Sent: 09 July 2021 10:26
To: Daniel Vick <Daniel.Vick@arun.gov.uk>
Cc: Neil Crowther <Neil.Crowther@arun.gov.uk>
Subject: 27,Central Drive

PROJECT	27 Central Drive - Elmer Beach	DATE	16/09/18
TITLE	Proposed South Elevation	DRG NO	IBA/507/05
SCALE	1 : 50	REVISIONS	B

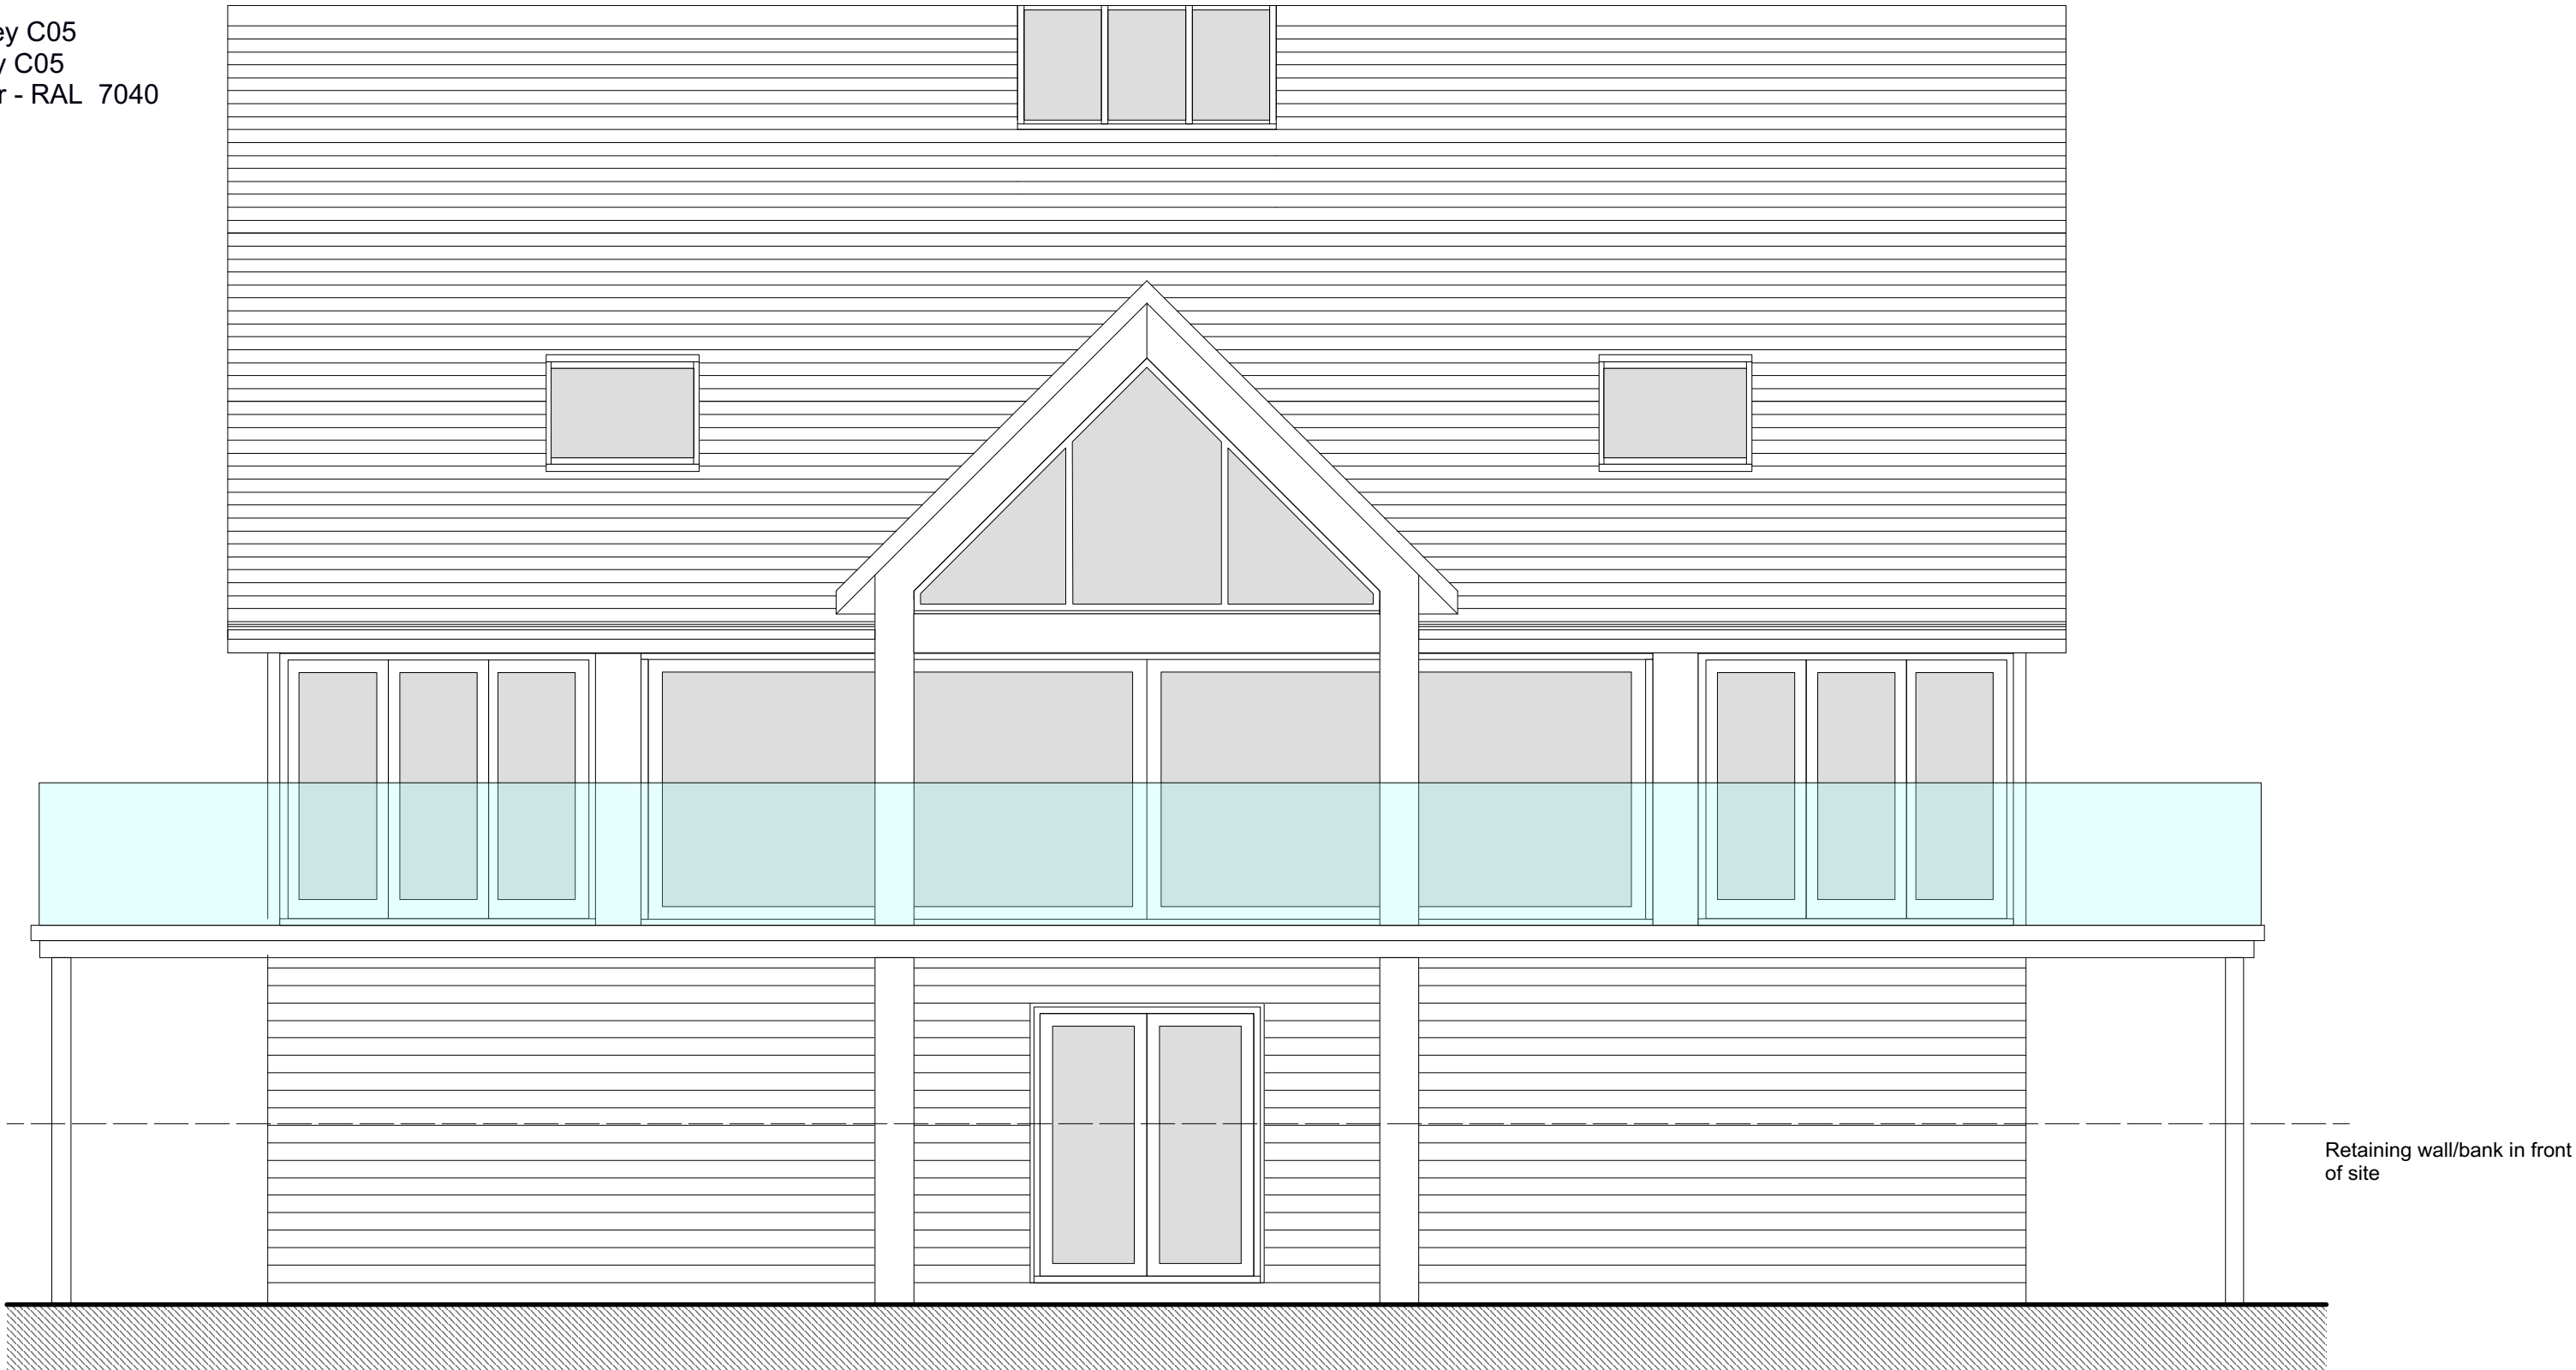
Leaving aside the relatively minor corrections to link extension, privacy screen, windows and finishes, the main significant part of the application is to delete the misleading street scene as a relevant document. No mention is made of the original elevations which were similarly misleading – albeit more authoritatively. I note however that revised elevations are provided which, unsurprisingly, unlike the originals which (see my emails of 3/7/21 and 11/7/21) should have been a significant part of the original considerations, do not show the relationship with the height of the neighbouring property.

There is in fact in the revised application no acknowledgement of any controversy regarding the overall height.
